Addendum No. 1

RE: Contract ID C203172

US-17 From Chowan River To Perquimans County and 2 Sections
Of Secondary Roads

September 18, 2012 Letting

MILLING ASPHALT PAVEMENT, 0" TO 2" DETAIL FOR BRIDGES OVER PEMBROKE CREEK

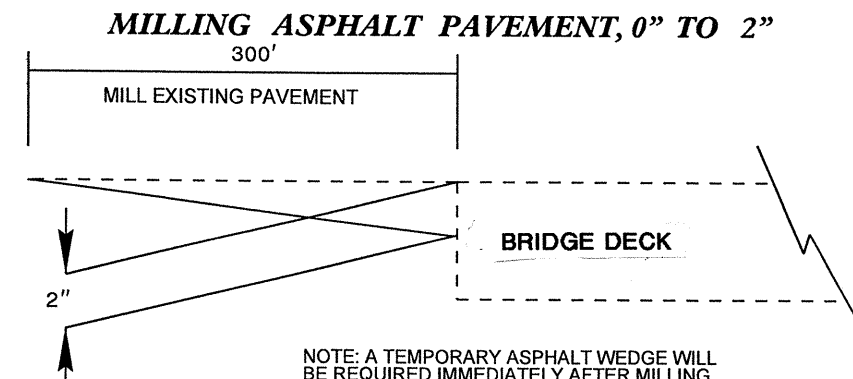
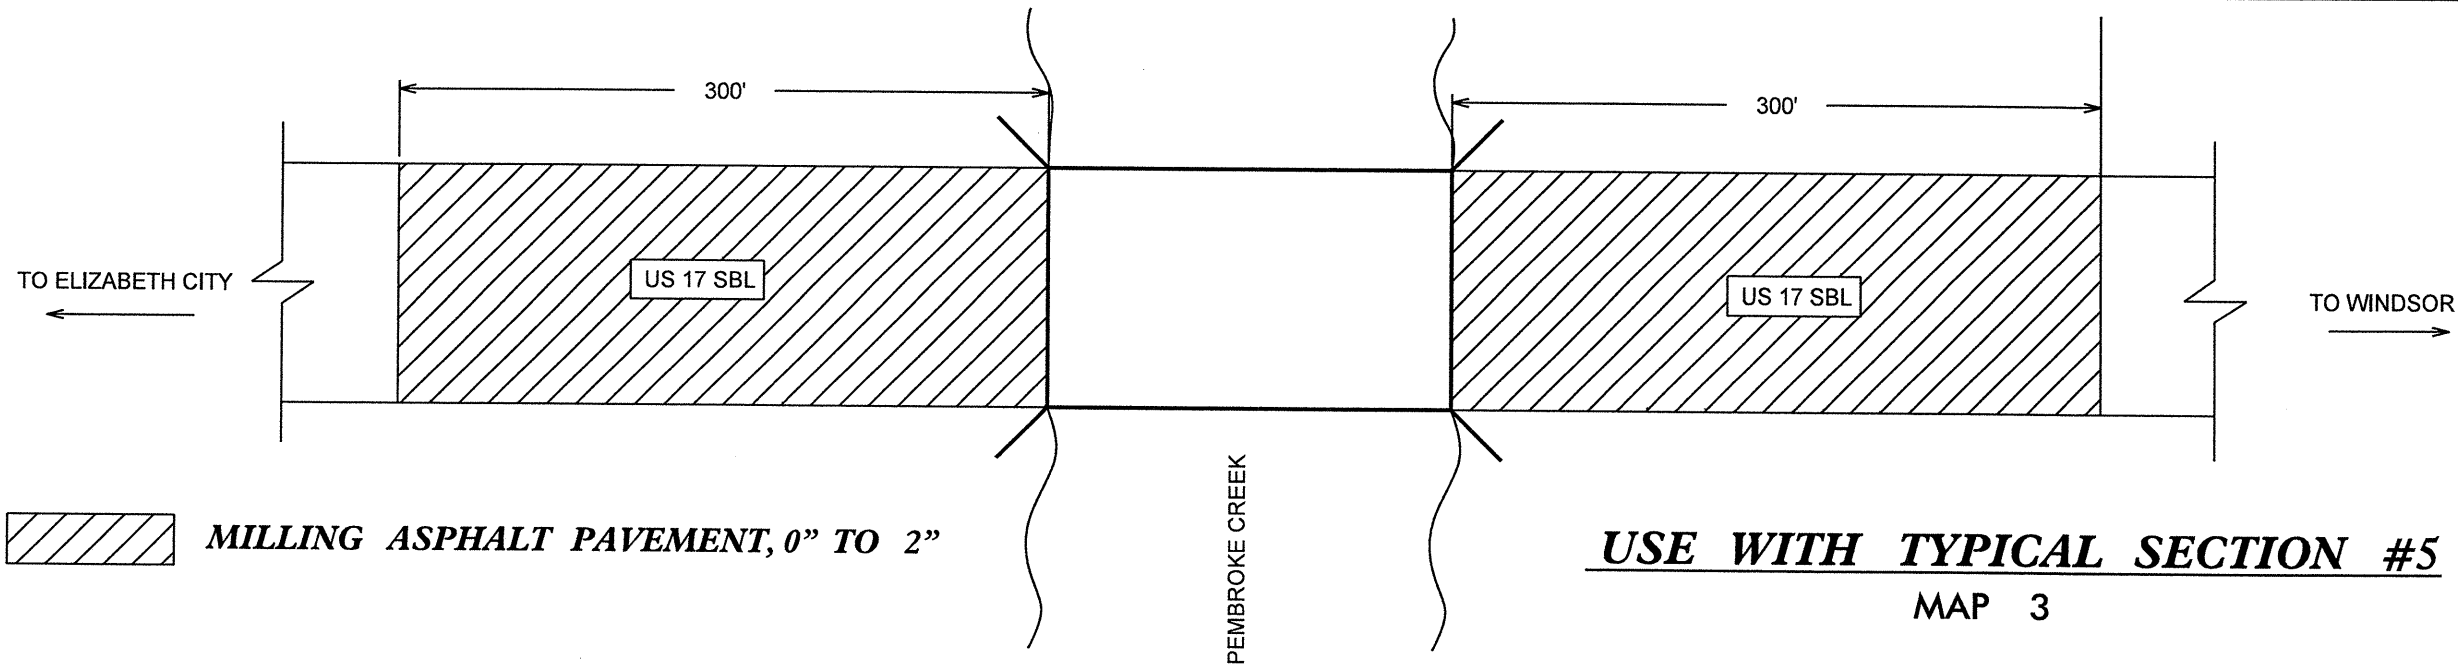
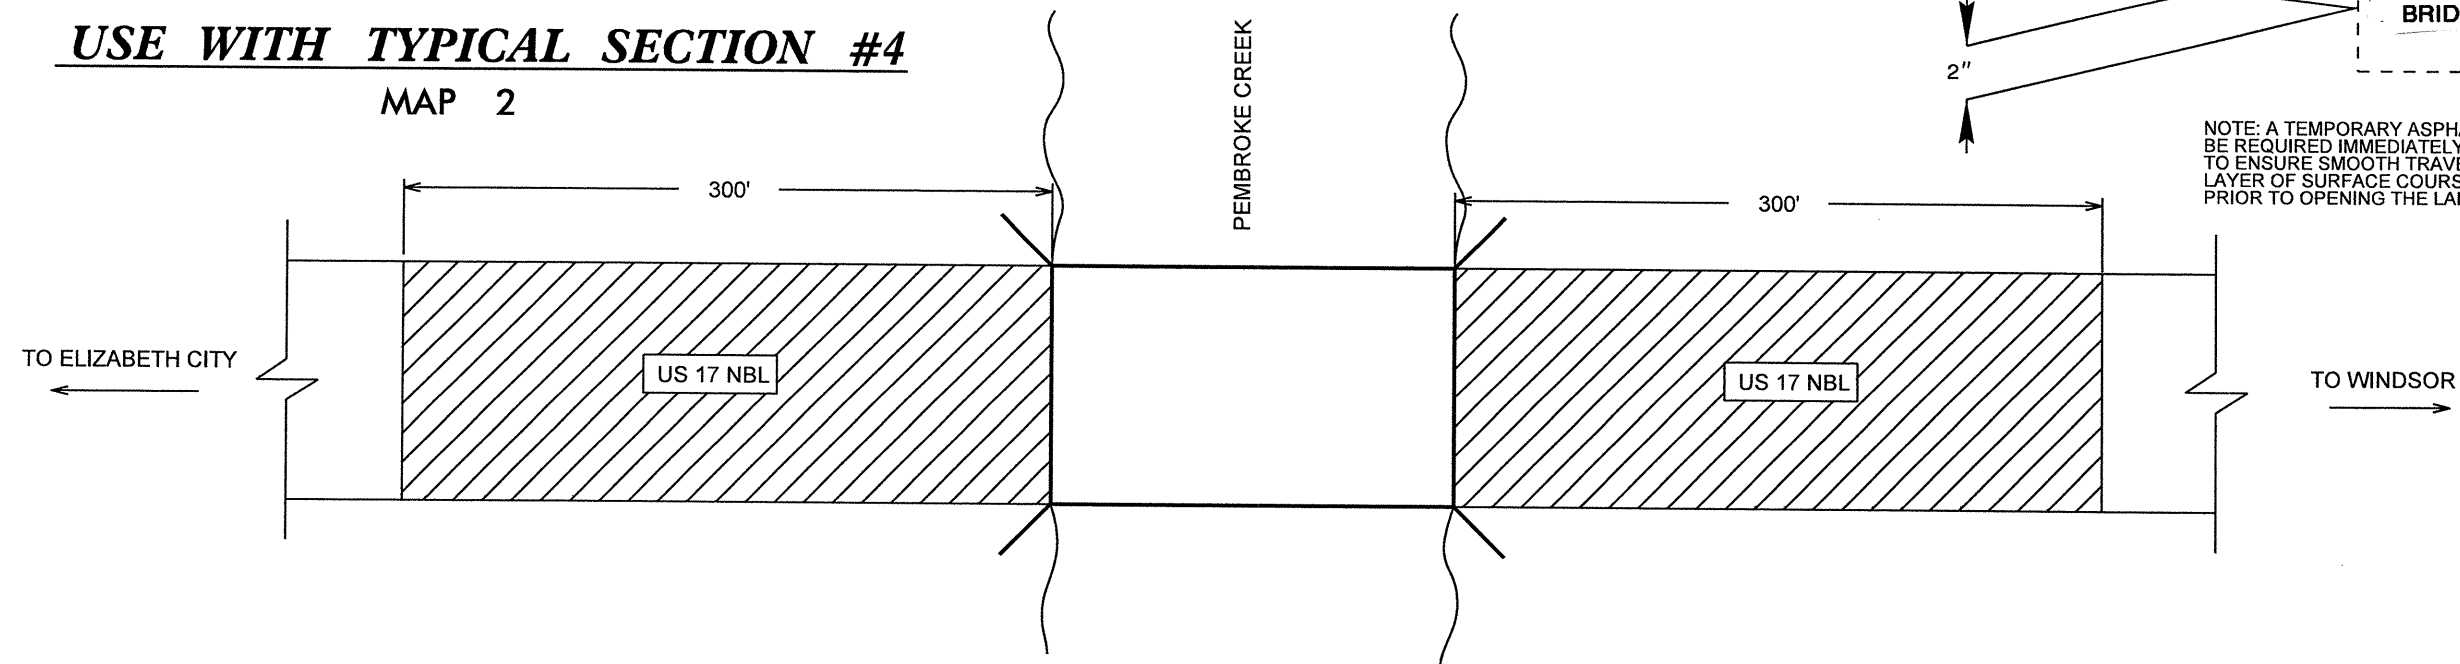
New Sheet No. 4A has been added to include a detail for variable depth milling at bridge approaches. Please staple new Sheet No. 4A after Sheet No. 4 in your plans.
